Application No: AB/59/20/PL
Site Address: 65 Tarrant Street Arundel BN18 9DJ
Description of works: Change of use of loft space from office storage to office work space & 2 No dormer windows to roof. This application affects the character & appearance of the Arundel Conservation Area. This application is not CIL Liable as in CIL Zone 2, (zero rated) as 'other development'.

Thank you for your internet representation made on 8th July 2020 which has been recorded as an objection with the comments as follows:

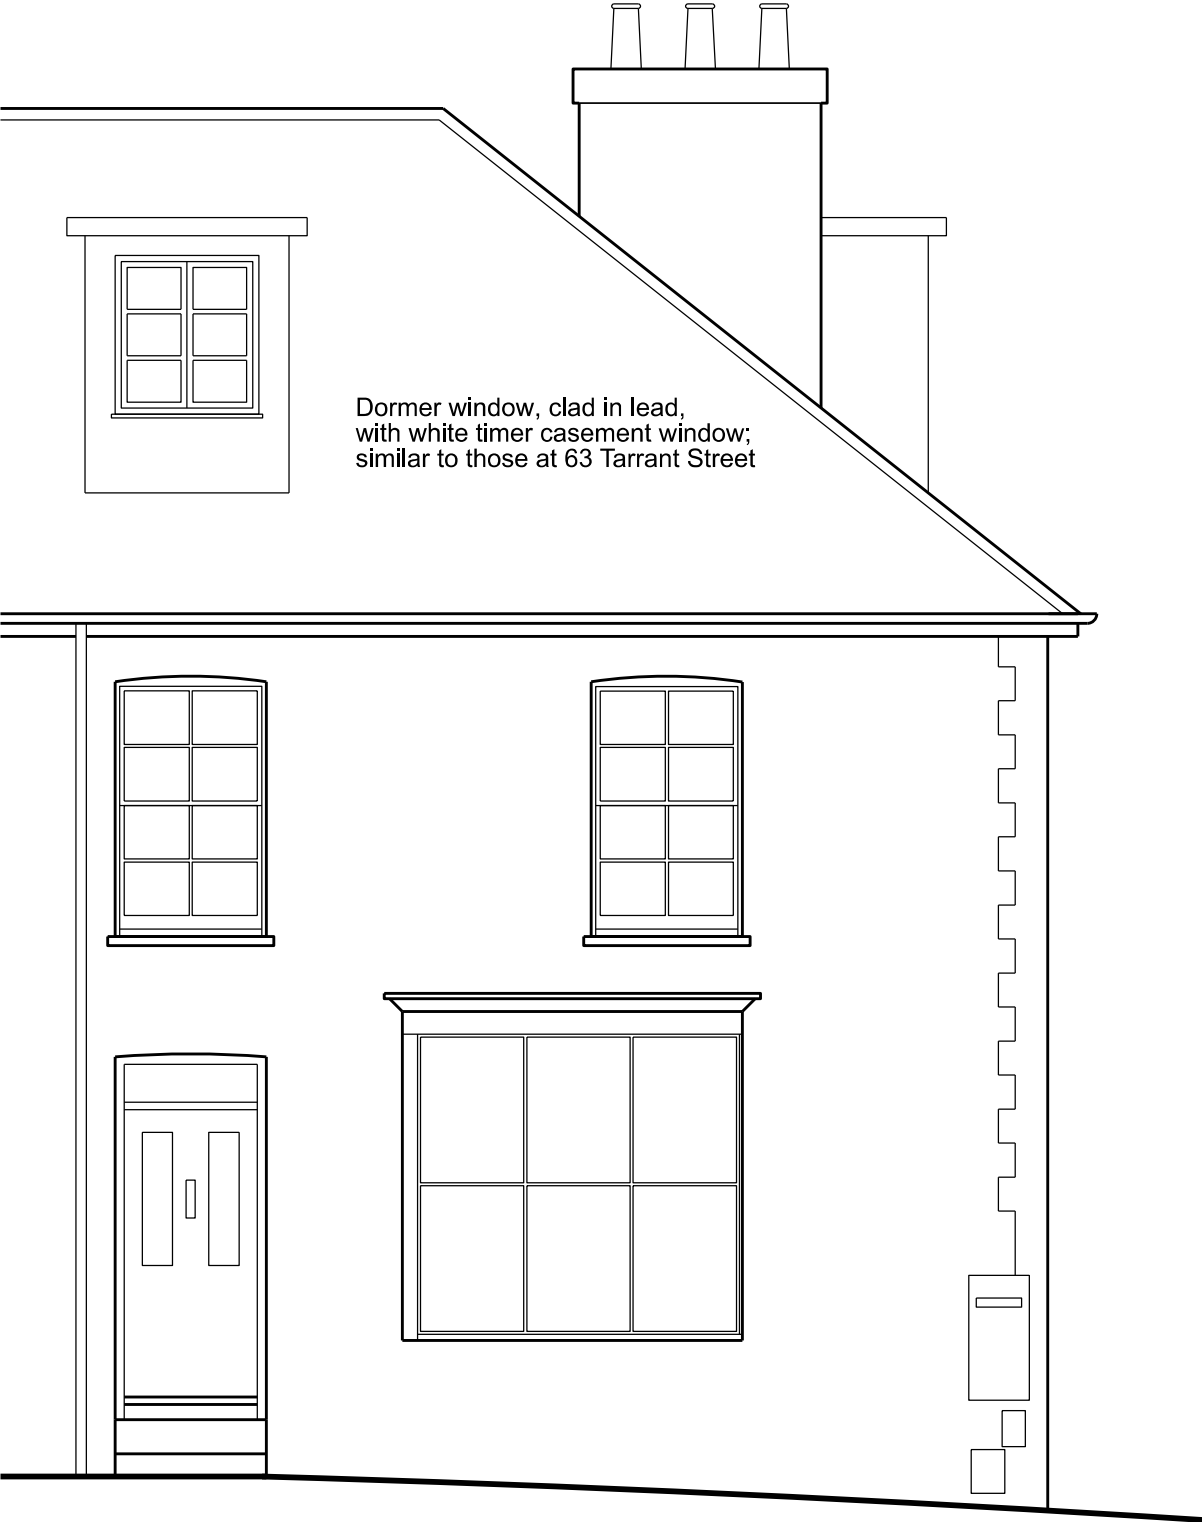
The dormer windows installed in no 61 Tarrant Street have proven to be rather too large and to introduce another one of the same size on the north elevation of no 65 is likely to be over-dominant, particularly when viewed from the west.

The dormer window proposed for the west (Arun Street) elevation is too large in relation to the scale of the roof and, in addition, it will give rise to a crowded appearance given the proximity of the chimney stack. This will be detrimental to the appearance of the building, the character and appearance of the conservation area and the setting of nearby listed buildings.

The introduction of lead covered dormers on the application site of a more modest size and massing, for instance similar to those on the roof of no 34 Tarrant Street (Queen's House) opposite, would be likely to be much more satisfactory.

It is considered that due to their size and massing the proposed dormers, particularly the one proposed for the west (Arun Street) elevation, will fail to comply with the relevant paragraphs of the NPPF 2019 and policies contained in the Arun District Local Plan 2018 relating to the protection of designated and non-designated
